Our ref: DOC19/1043099

Senders ref: SSD 8114

**Subject: Request for Advice on Response to Submissions – Lindfield Learning Village
phase 2 and 3 (SSD-8114)**

Attachment 1 – EES comments on Lindfield Learning Village phase 2 and 3 (SSD-8114) – Response to Submissions

**Figure1.12 Ground Level Evacuation Plan**

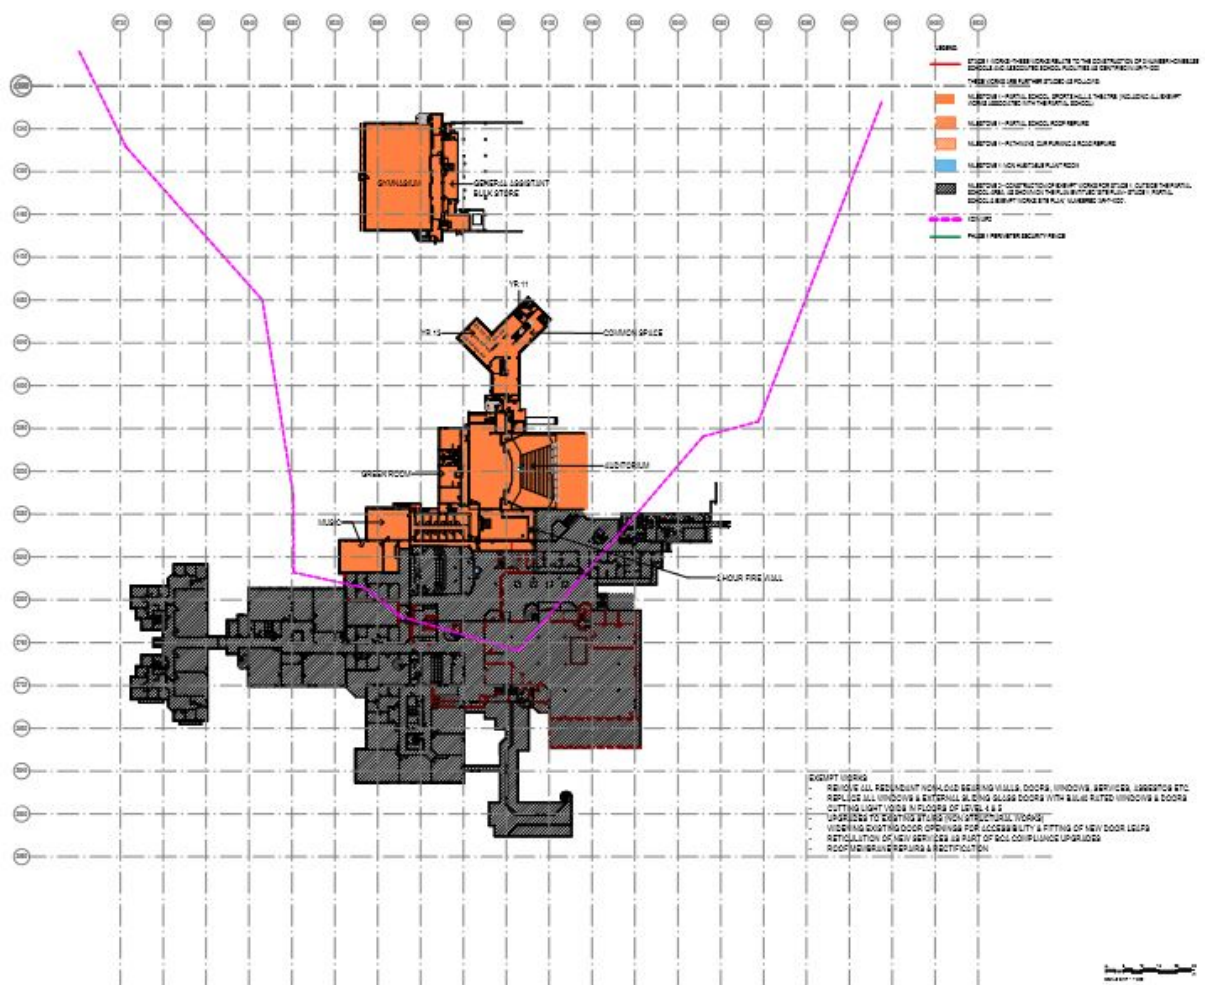
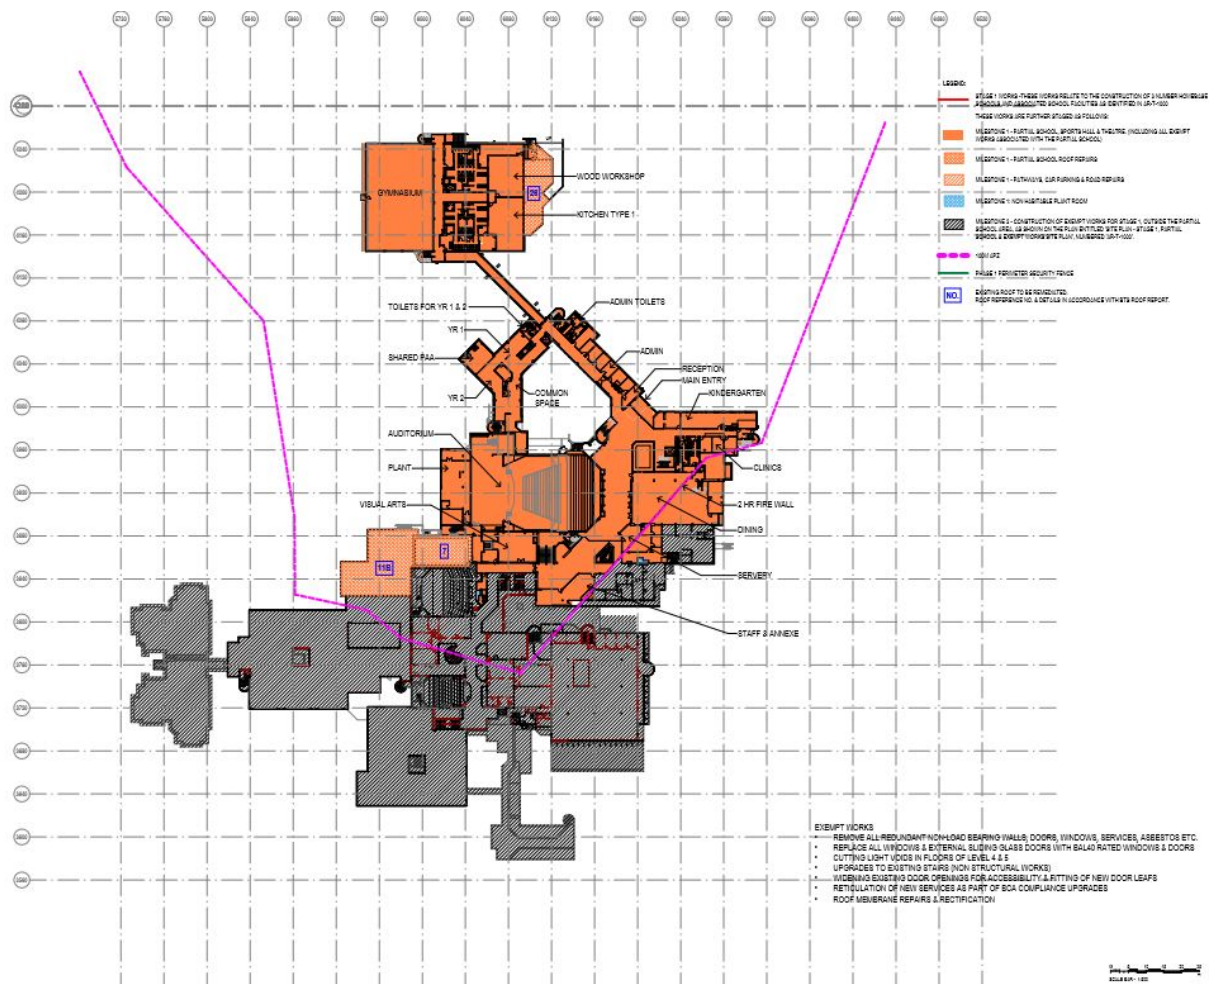
The second paragraph states that *"The Auditorium has been nominated as the emergency assembly point for the proposed development. Levels in this area range from approximately 59m AHD to 63m AHD, above the 1% AEP flood level which would be approximately 200 to 250mm above the exiting levels. As a result, the most vulnerable students should be positioned at the top of the stairs at the highest point, including kindergarten and students with mobility limitations"*.

EES advises that the above general paragraph is not adequate for flood emergency for the proposed learning facility. Learning facilities can be classified as Special Purpose Facilities. From a floodplain risk management perspective, a new facility should be planned to have flood refuge area with a floor level greater than or equal to the PMF flood level, with acceptable structural soundness of its buildings and available road access up to the PMF. Moreover, in determining the impact of flooding on the site the flood assessment should consider the vulnerability of the site users, particularly students, teachers, parents, carers and other members of the school community.

Figure 7.1 IFD duration table.

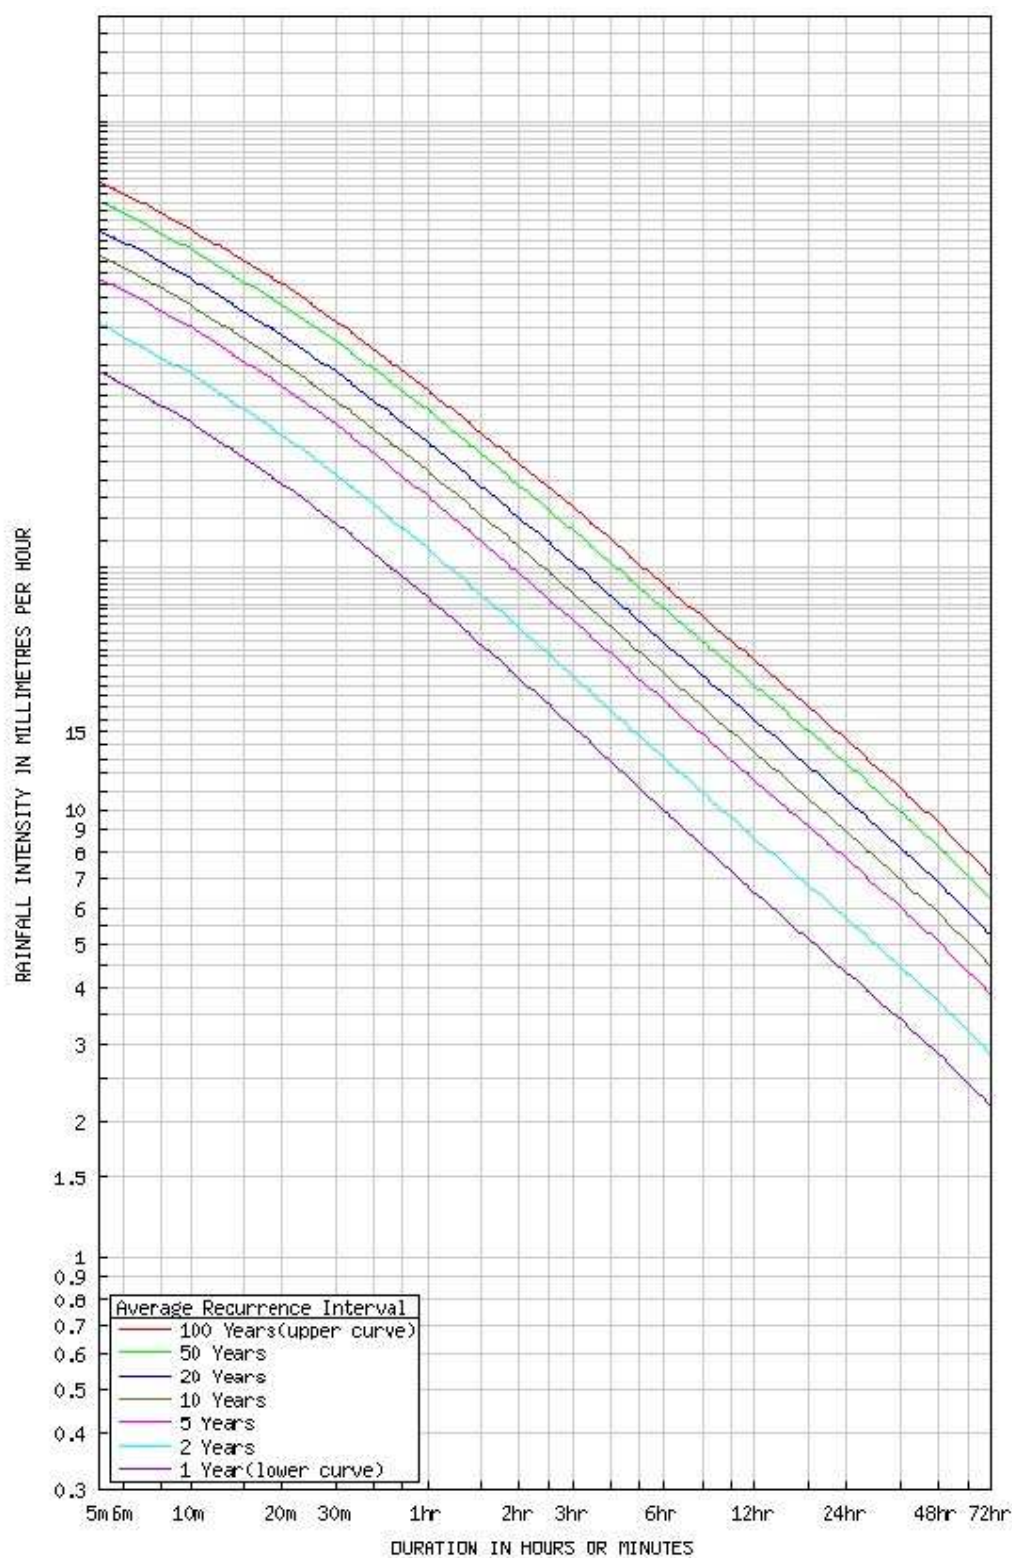
Section 3.1 also indicates that the DRAINS model utilised 2016 AR&R ensemble methodology. However, section 3.2 indicates that rainfall data is derived from 1987 AR&R.

ESS recommends that the consultant clarify this matter. In addition, adopted loss parameters has not been mentioned in the report.
